Agency and Issue	Comment
Liverpool Council	
The current zoning makes provision for the purpose of Health Service Facilities and Educational Establishments. Given the nature of the proposed development and use, it renders the proposal an ancillary use to the existing master plan of the Liverpool Hospital Redevelopment and thus permissible within the current zoning.	Noted
SITE CONSTRAINTS	
<i>Building Height</i>	
In accordance with Liverpool's Local Environmental Plan 2008 (LEP 2008), and associated maps, the subject site is restricted to a maximum building height of 35m above ground level. It is calculated from the submitted elevation plans that the building height is approximately 21.7m from the natural ground.	Noted
It shall be noted that Council raise no objection with regards to the height of the building.	
<i>Floor Space Ratio</i>	
In accordance with Liverpool's Local Environmental Plan 2008 (LEP 2008), and associated maps, the subject site is restricted to a maximum floor space ratio of 2.5:1. Provisions of the plan also provide for circumstances under which a building in the Liverpool City Centre may exceed the maximum Floor Space Ratio shown for the land on the Floor Space R

FLOOR PLAN - BASEMENT

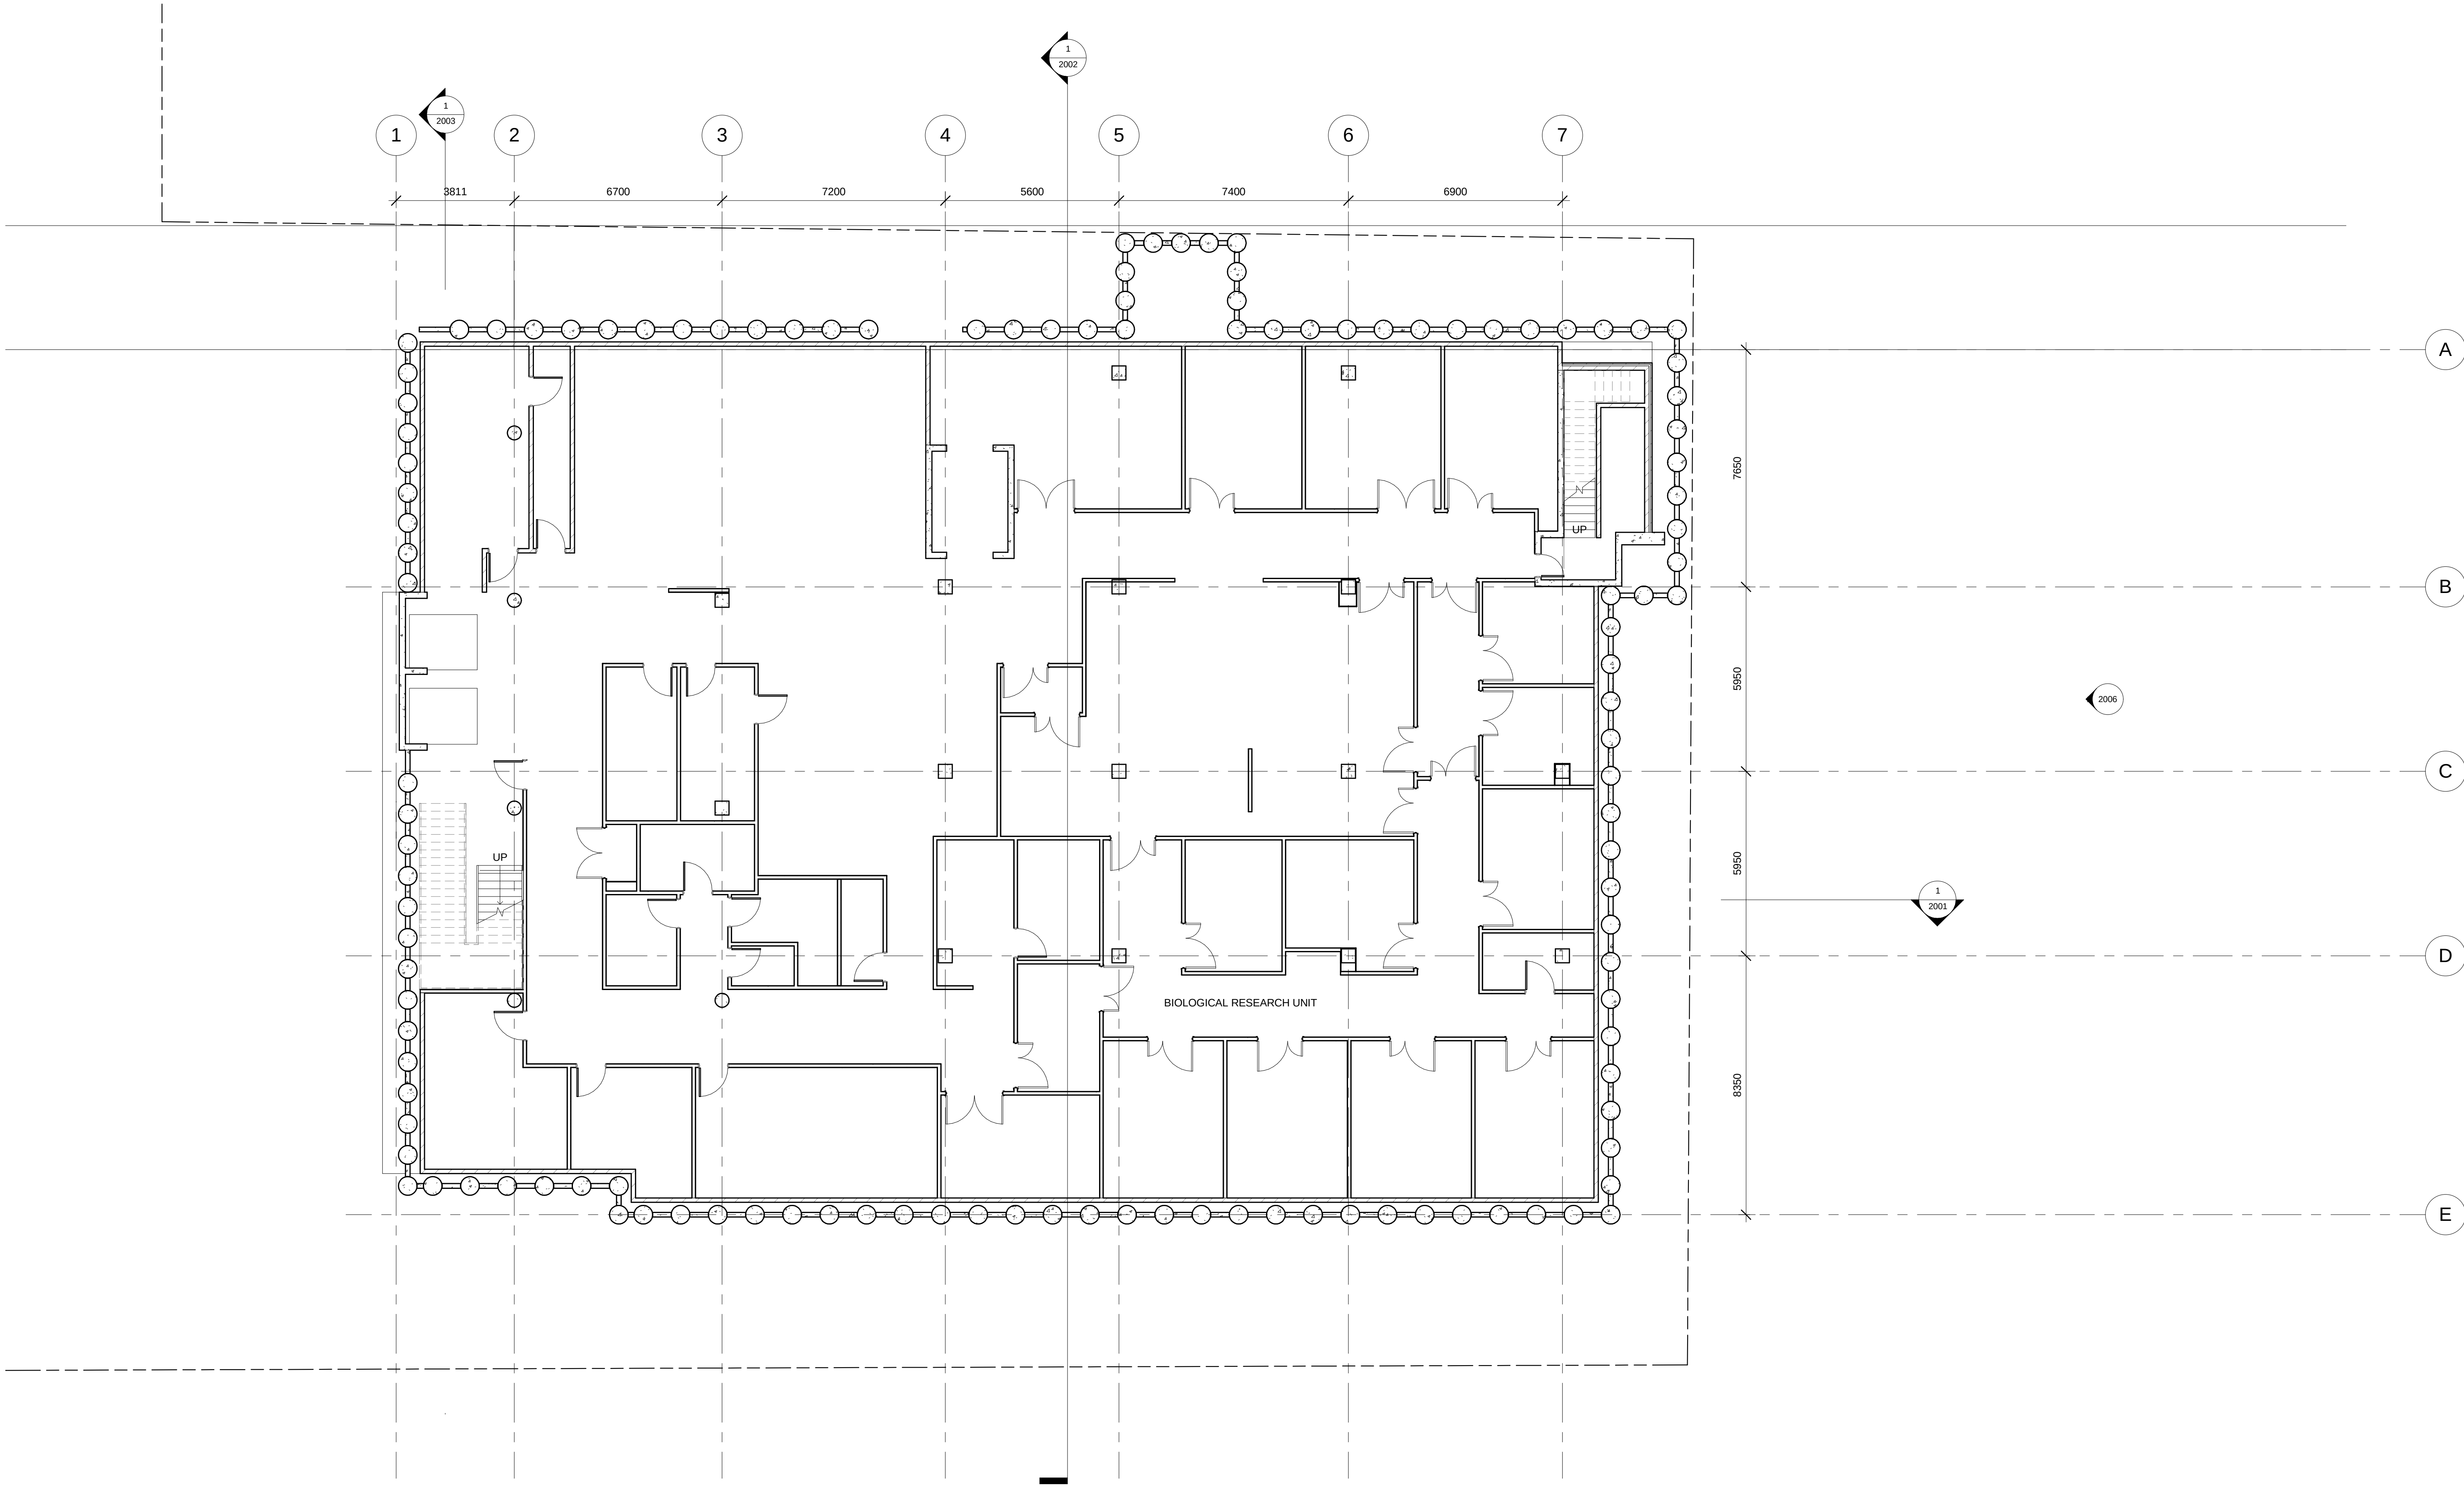
NSW Transport	
The applicant should identify the quantum and location of bicycle parking facilities and amenities. Specific cycle parking should be provided for the proposed development located in an accessible, well lit and secure areas.	The architectural drawings show a secure bicycle parking area able to accommodate up to 20 bicycles. The rate of bicycle parking required based on the sustainable transport guideline is 1 space per 20 staff members. This would require 15 bicycle spaces. The proposal more that addresses this requirement.
The proponent address pedestrian and cycle access issues during construction. Truck movements during construction could conflict with pedestrian and cycle movement between the Hospital complex and Liverpool and Warwick Farm stations. Particularly at the truck entry and exist points on Goulburn and Forbes Streets.	This issue will be addressed prior to construction as part of the Construction Environmental Management Plan and the Traffic and Pedestrian Management Plan as per Commitments P4 and P7 respectively.
